**RE: #6 Canyon LLC Segregation, File Number SG-08-00036**  
**Parcel Numbers: 955113 & 783034**

TO: Jeff Watson, Community Development Services  
FROM: Christina Wollman, Planner II *W*  
DATE: December 22, 2008  
SUBJECT: #6 Canyon SG-08-00036.

TO: Kari Braniff, CDS  
FROM: Christina Wollman, Planner II *CW*  
DATE: November 24, 2008  
SUBJECT: #6 Canyon LLC SG-08-36. 20-15-21000-0016, 20-15-21040-0001.

RECORD OF SURVEY FOR ADMINISTRATIVE SEGREGATION

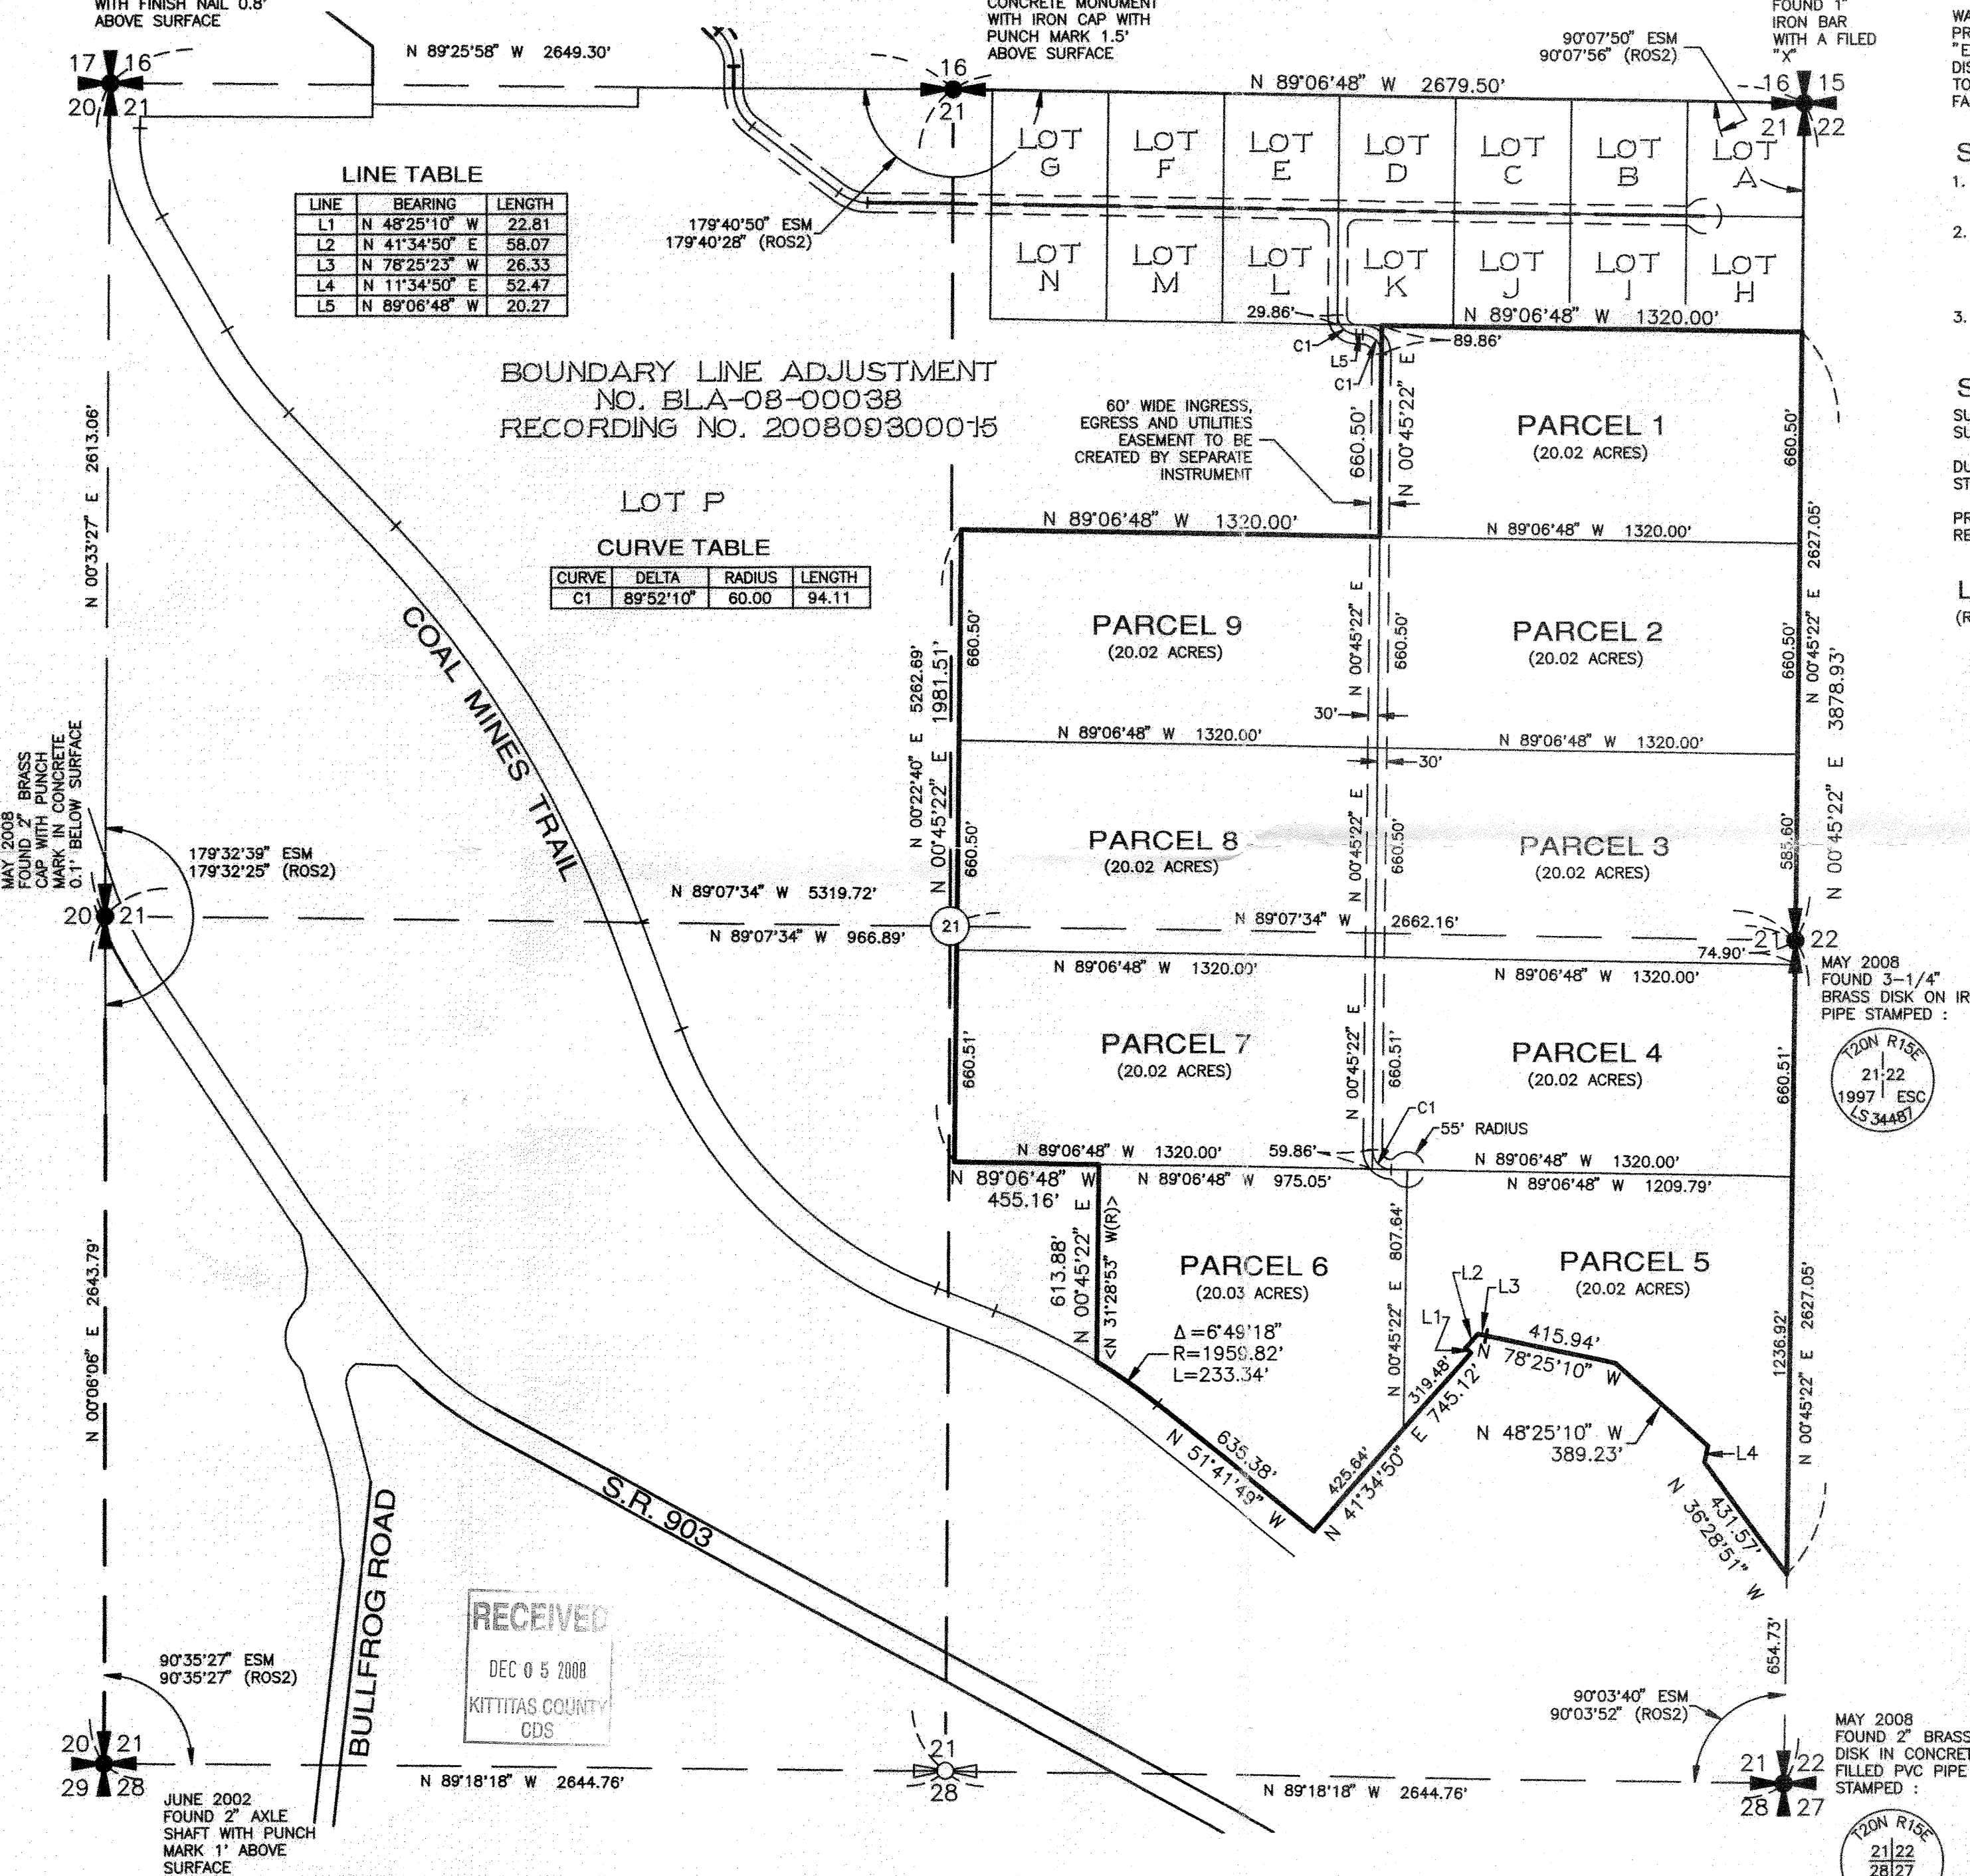
In order to review the segregation application, 60' access easements need to be shown on the survey. A cul-de-sac with a radius of 55' needs to be shown at the end of all roads.

PUBLIC WORKS
Forgot to show access
